In the matter of ABP-320094-24

Proposed 400kV Gas insulated SwitchGear electricity substation and high voltage transmission lines/cables and electric plant, Coolpowra, Co. Galway

Observation	ABP-320094-24 — Proposed 400kV Gas insulated SwitchGear electricity substation and high voltage transmission lines/cables and electric plant.
One project	Co-located and, on the applicant's own concession, functionally connected: this GIS; the Reserve Gas-Fired Generator (ABP-320095-24); and the Long Duration Energy Storage Facility (ABP-320916-24).
Applicant	Coolpowra Flex Gen Limited (and related entities).
Submitted by	Eamonn O'Hara, Neale, Killimor, Ballinasloe, Co. Galway
Date	June 2026

TYPICAL SECTION THROUGH STREAM CROSSING No. 1
SCALE 1:25

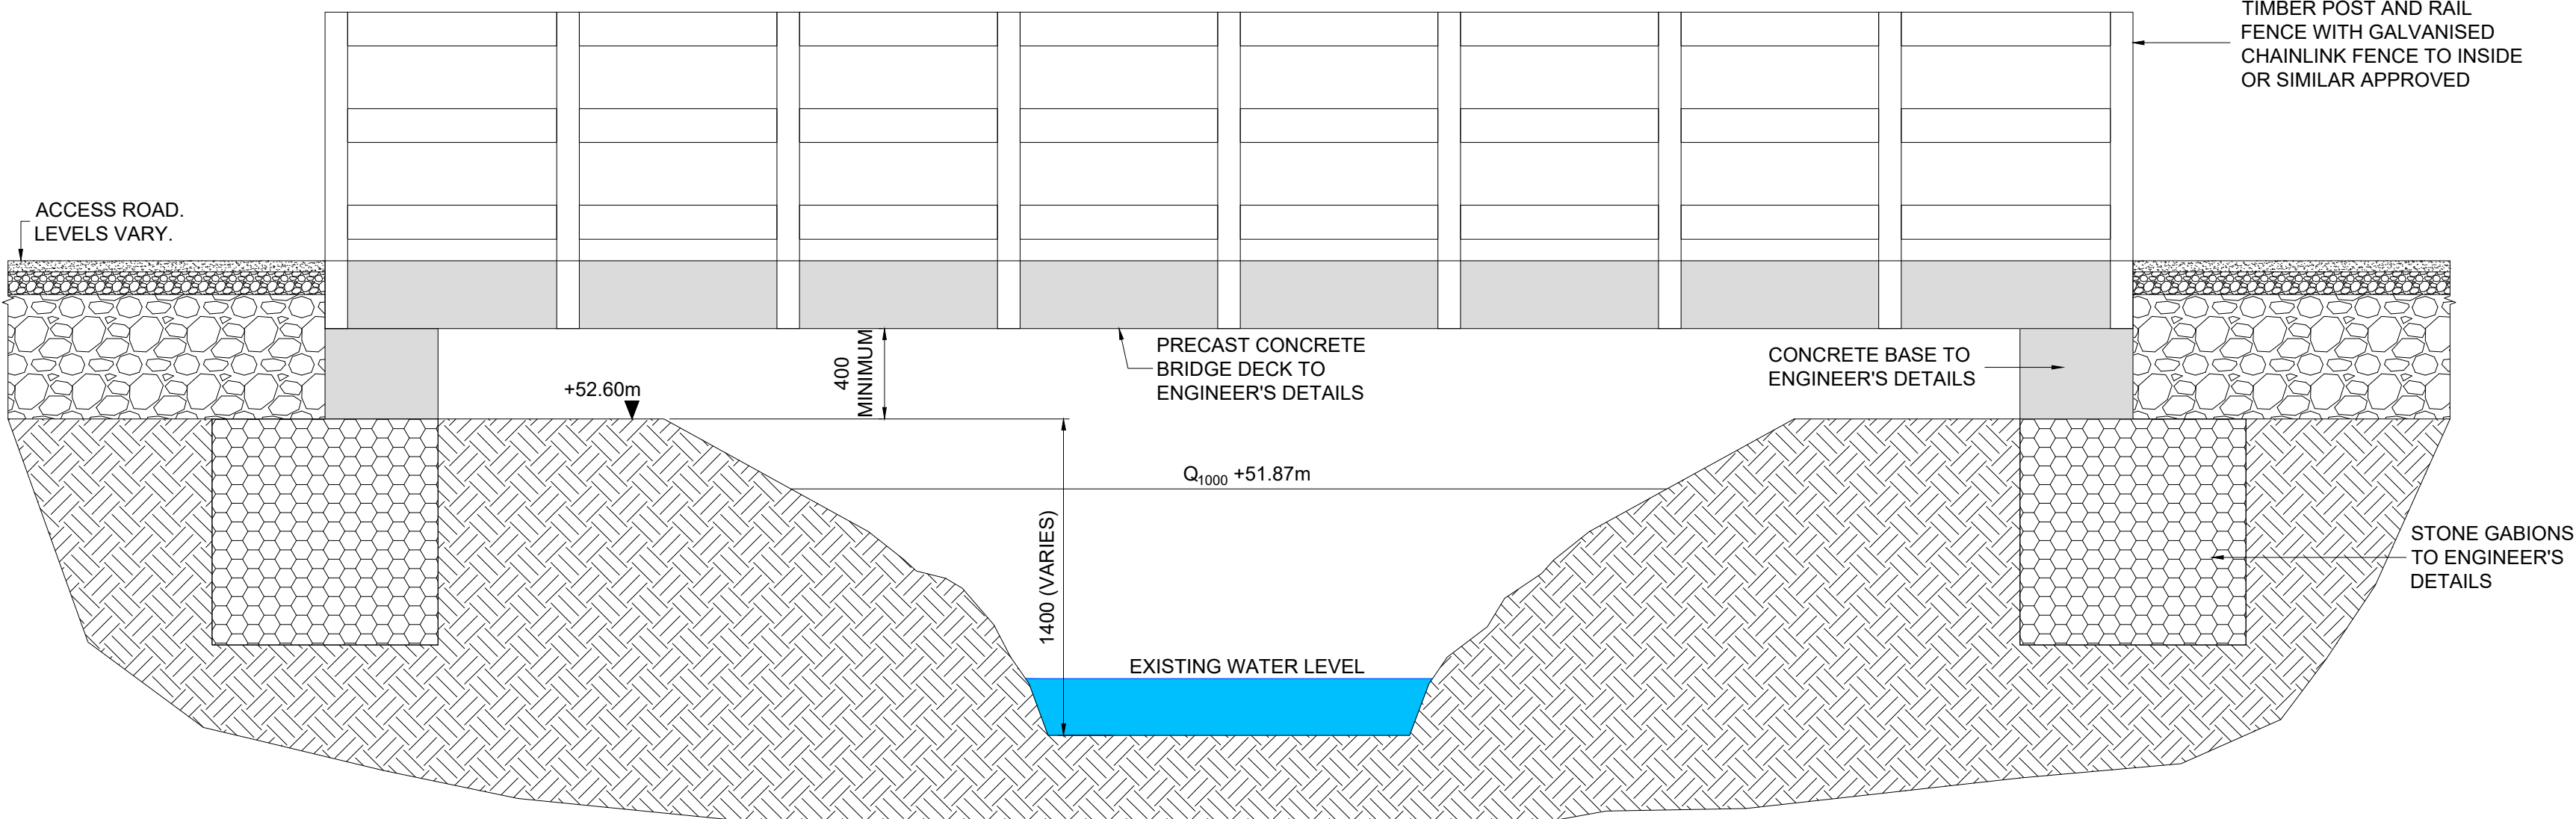
The deficiencies are these. No evidence of consultation with Inland Fisheries Ireland appears in the response, despite the express requirement. The "no fisheries value" claim is internally contradicted: the same material designs the realigned channel for "fish passage and spawning," and the downstream Kilcrow holds salmon, trout and eel. The claim rests on a walkover with no named fisheries author and no electrofishing data. It is also contradicted by the State's own science: the Treananearla is a tributary of the Kilcrow, which the genetic stock study (Magee et al., 2017) found to be among the lake's top contributing tributaries — about 11% of Lough Derg's adult brown trout, behind only the Camcor (13%). Absence of sampling is absence of investigation, not absence of value. The realignment is, moreover, justified expressly to "consolidate" the plant layout near the Oldstreet node — that is layout convenience, the opposite of the requirement to avoid impacts before mitigating them.
